# CITY OF ALBUQUERQUE

June 6, 2016

**RE: Lot 13  
Blue Sky Business Park  
Grading and Drainage Plan (Stamp Date 5-23-2016)  
Hydrology File: D16D002A5**

ZONE HAP NO. D-16 SHEET

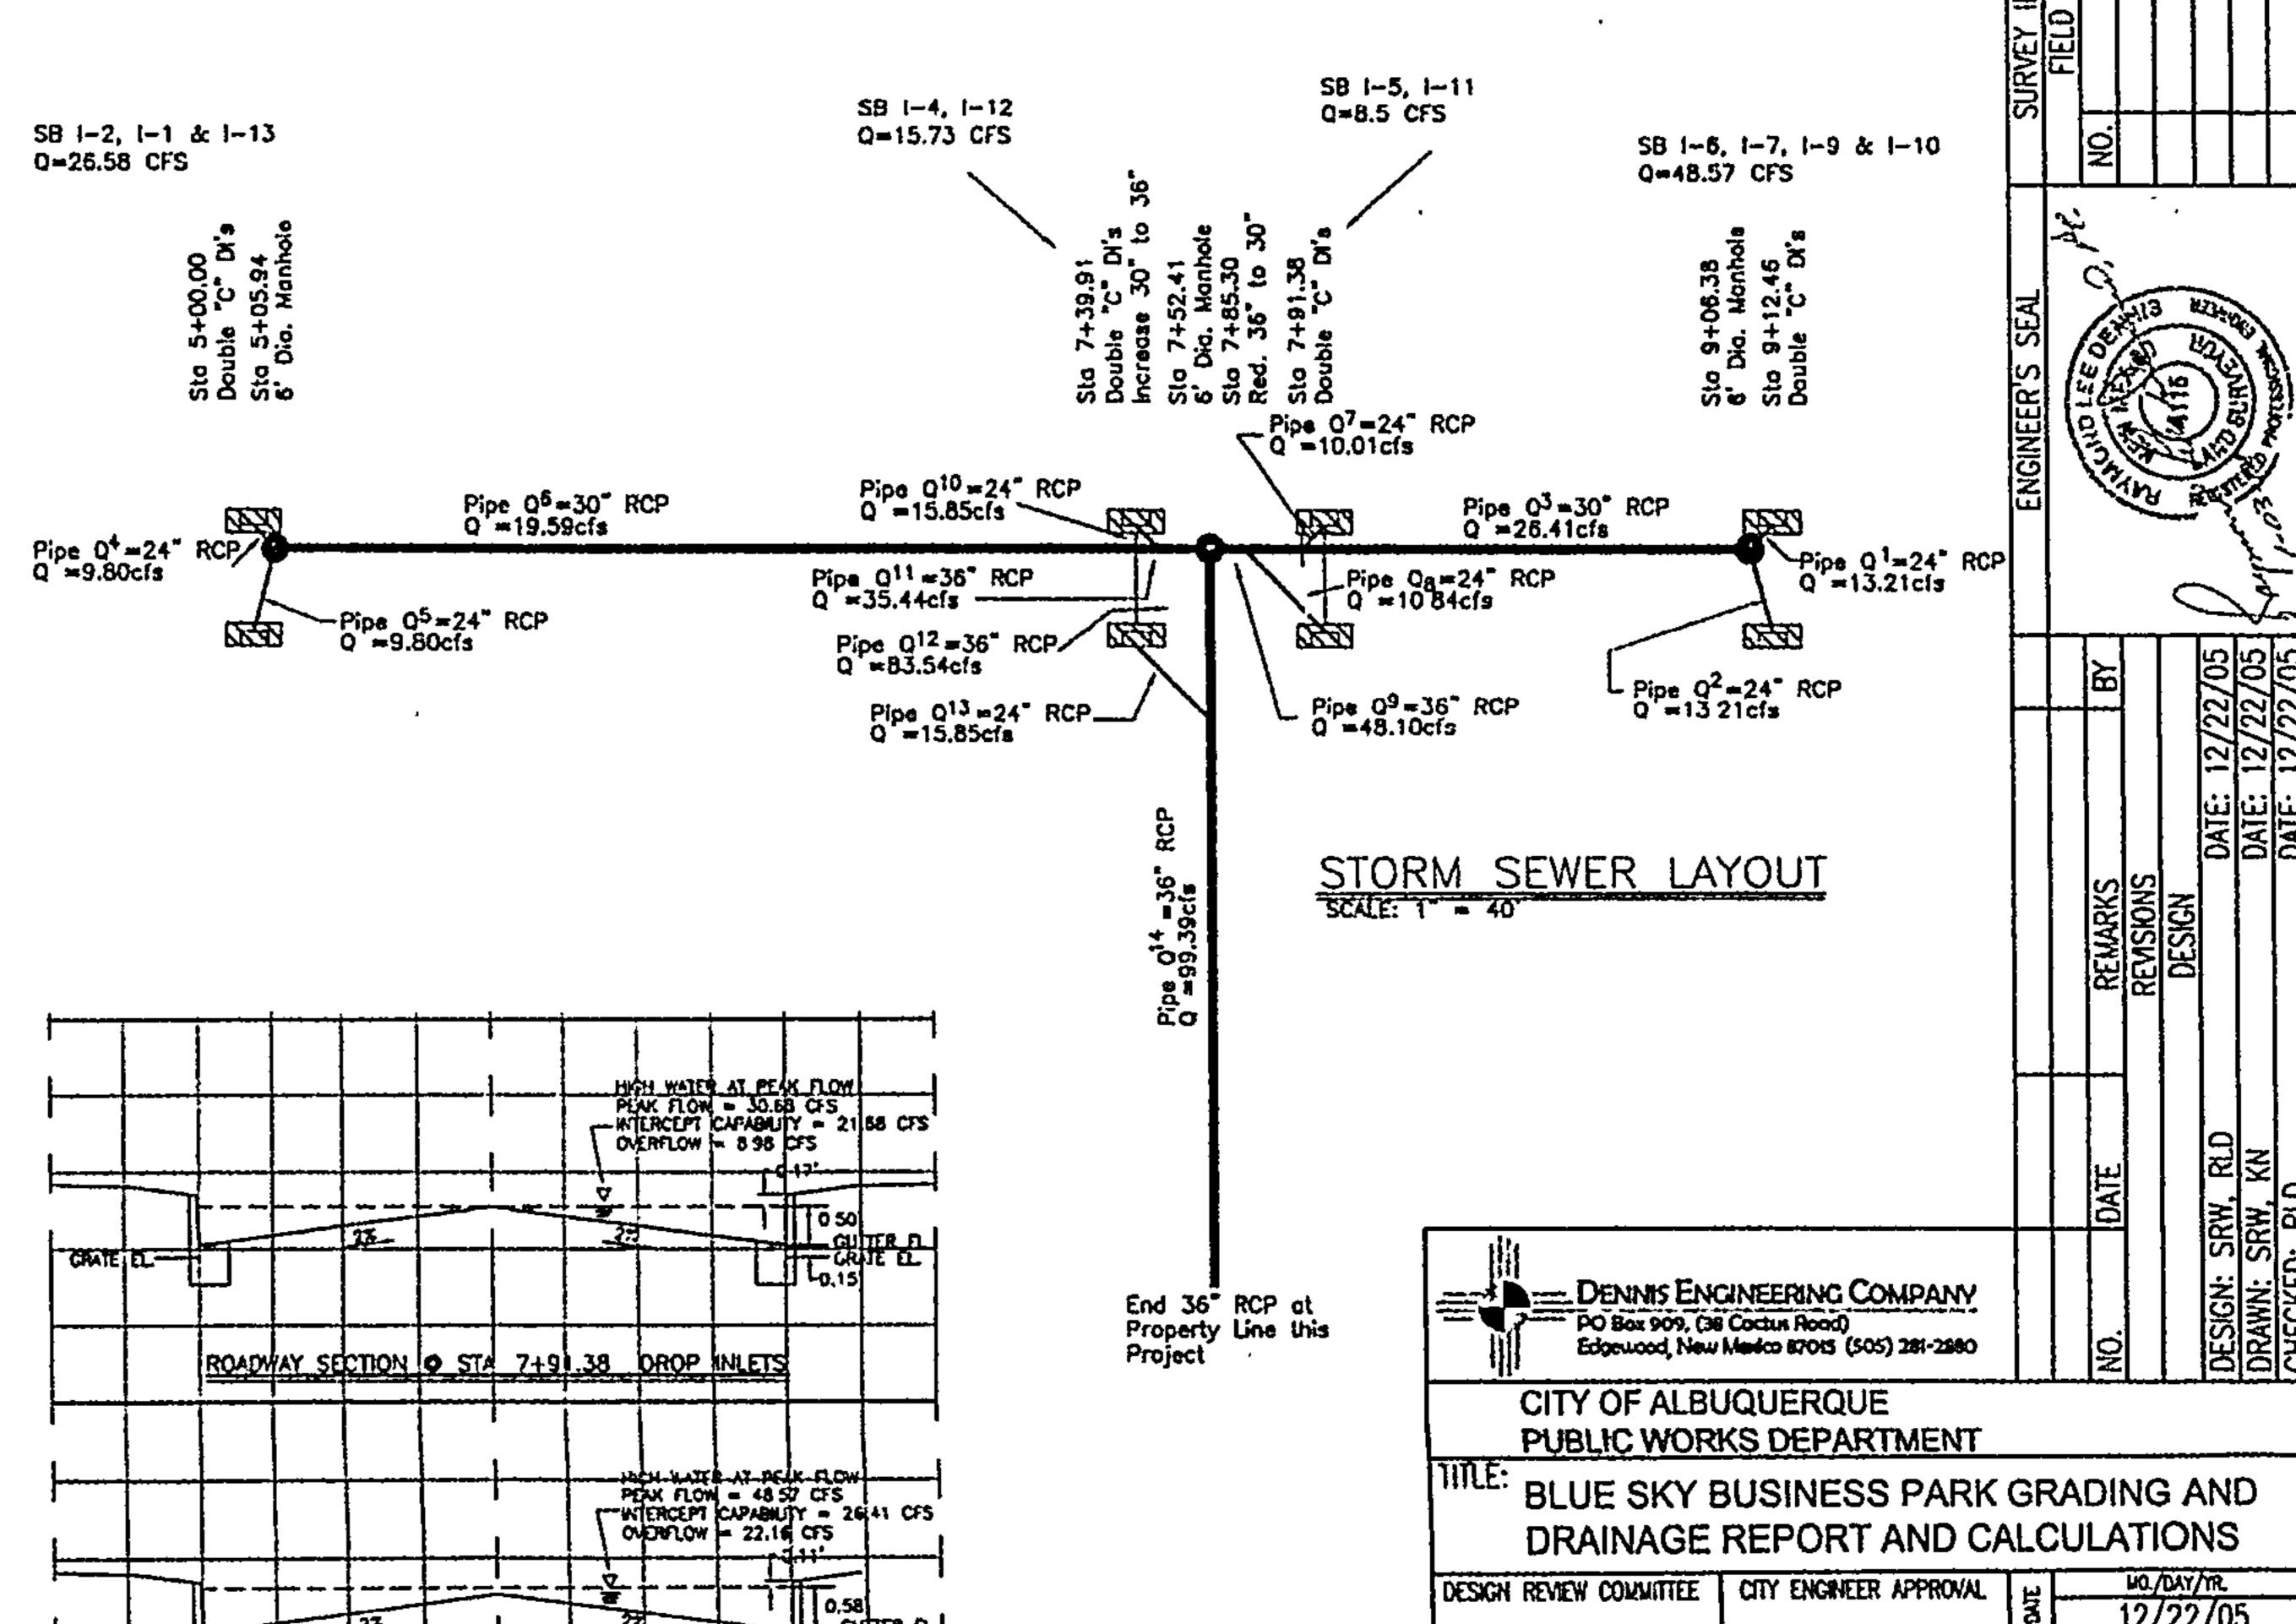
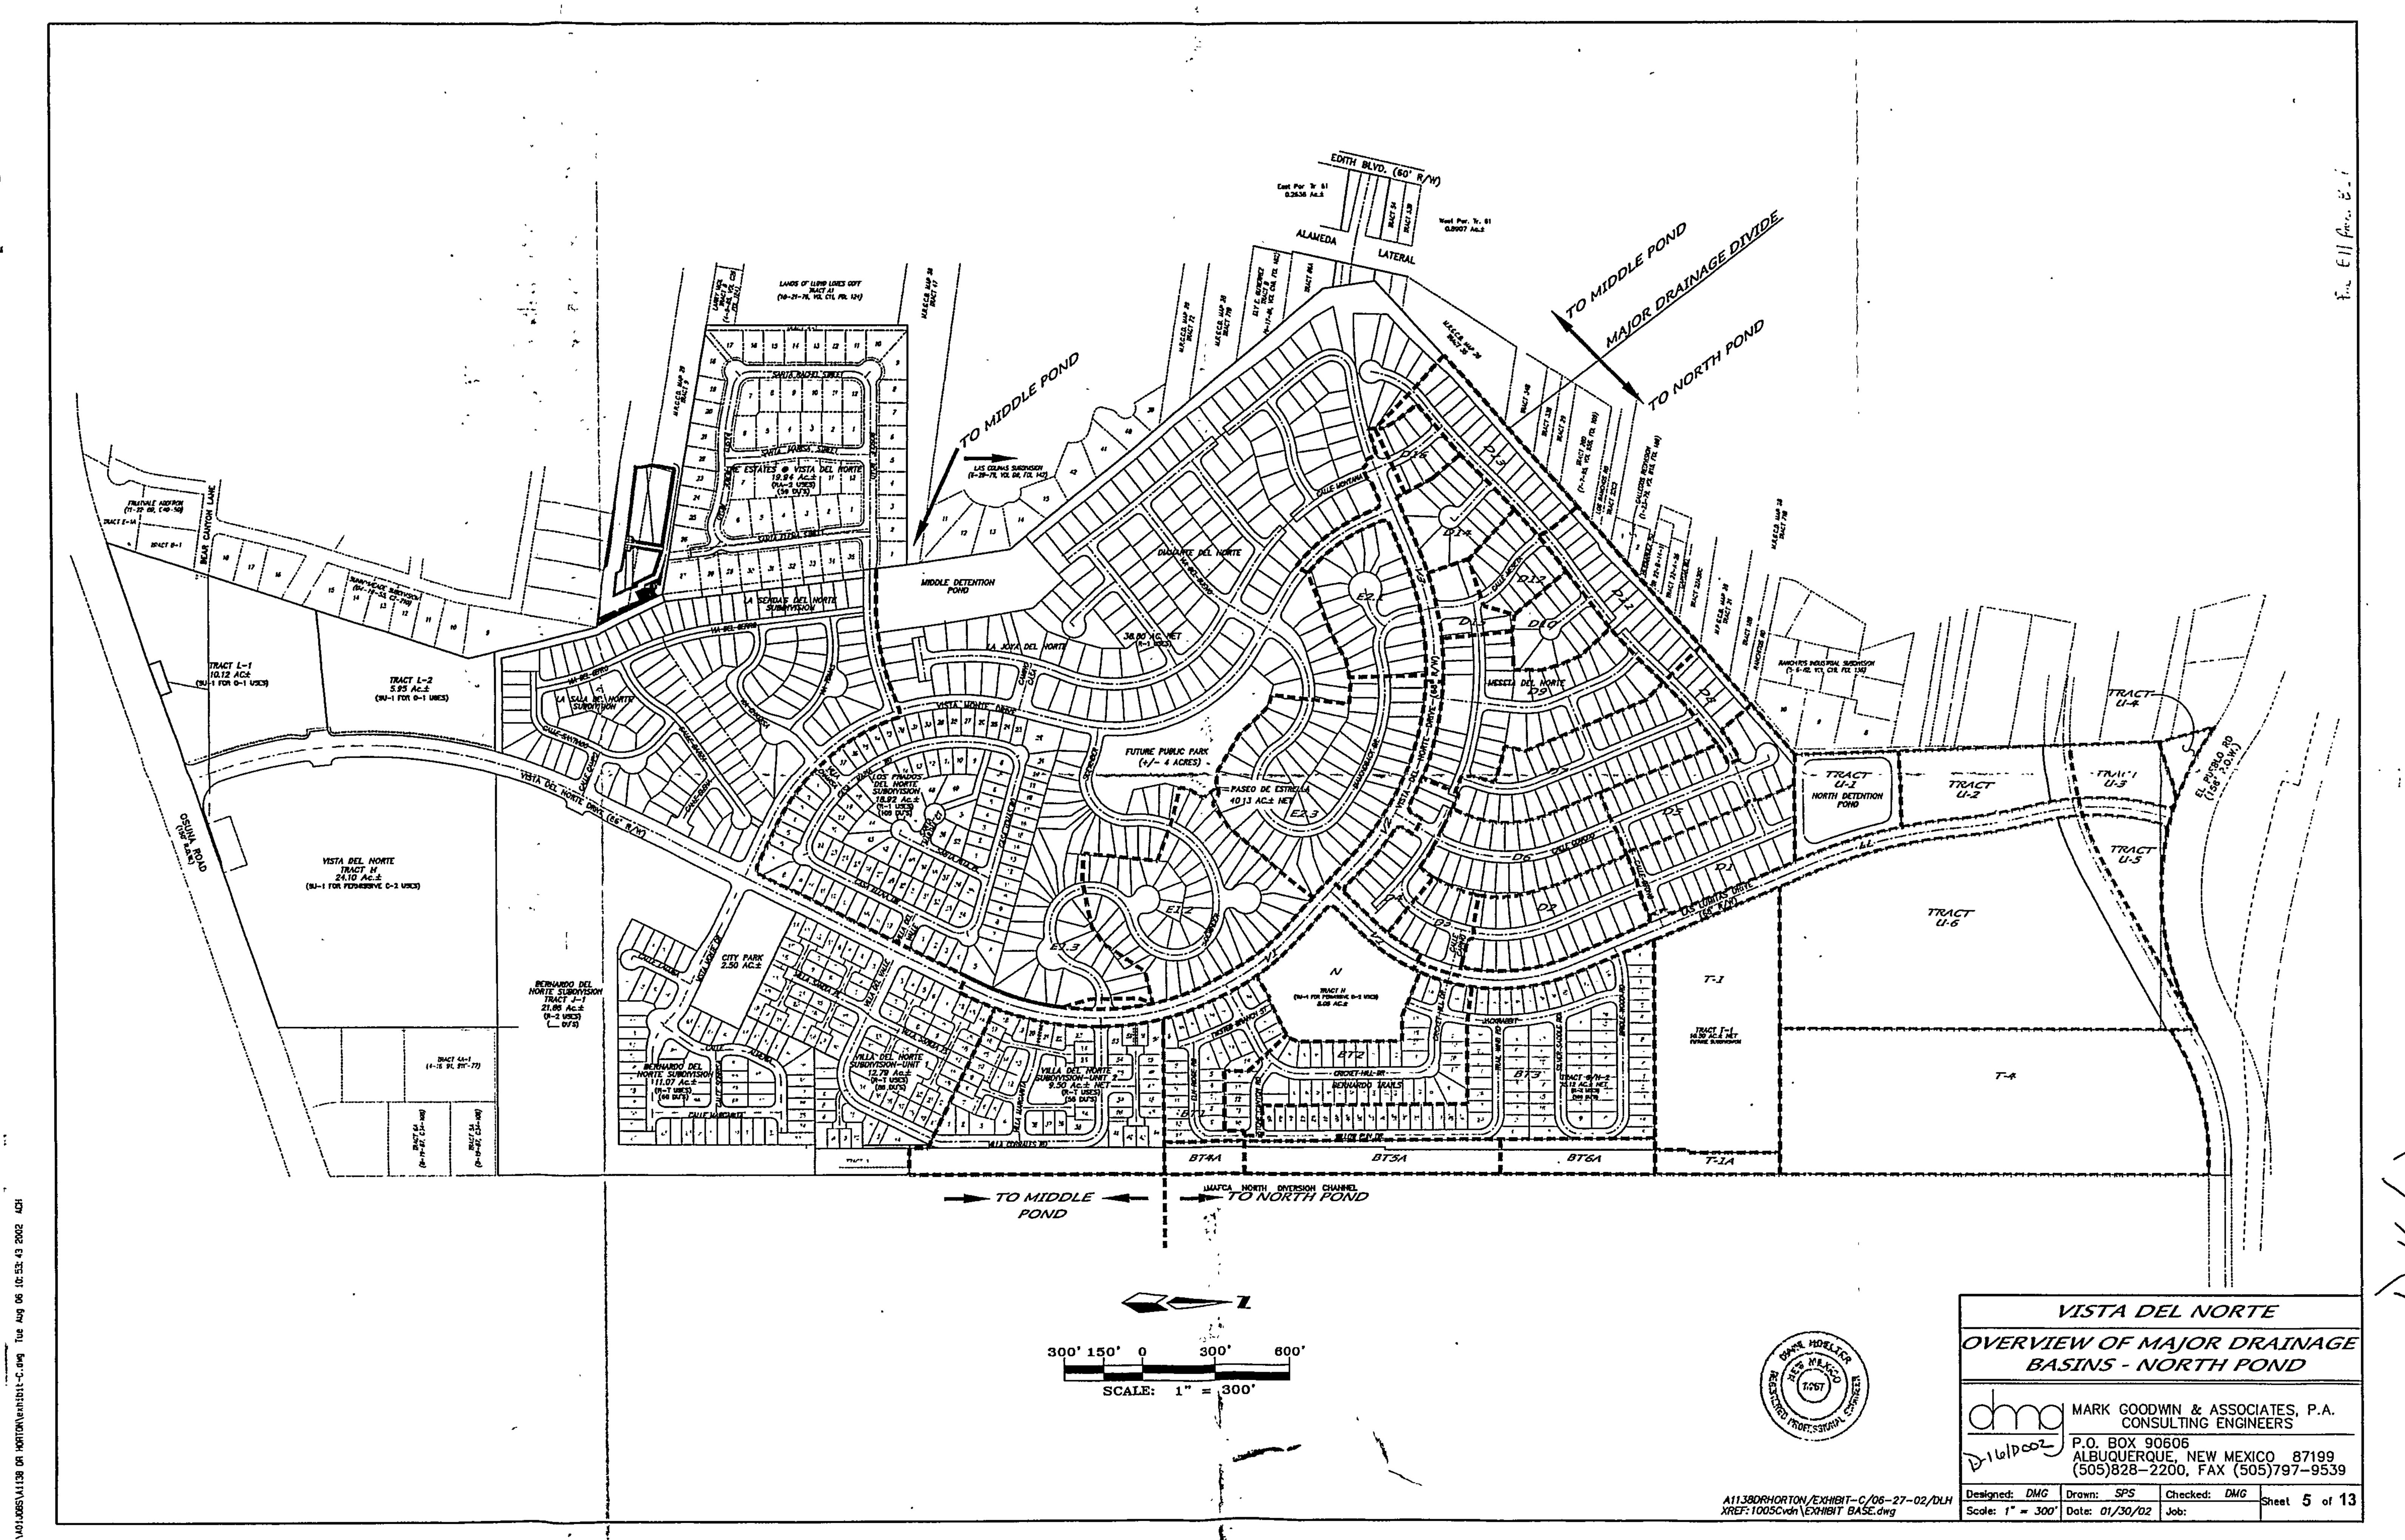
1. The perimeter wall that is proposed is shown conflicting with the utility boxes called out to remain. Furthermore, there will need to be concurrence from the Gas Company and the owner of the utility boxes to block off access, to place a wall within the gas easement, potentially over existing gas and other utility lines. Evidence of the Gas Company's concurrence will be required for Certificate of Occupancy approval. It should be the responsibility of the Owner/Owner's Representative to coordinate with the utility company, not the Contractor's during construction.
2. Please make sure the Contractor adheres to the attached SO-19 Building Notes.
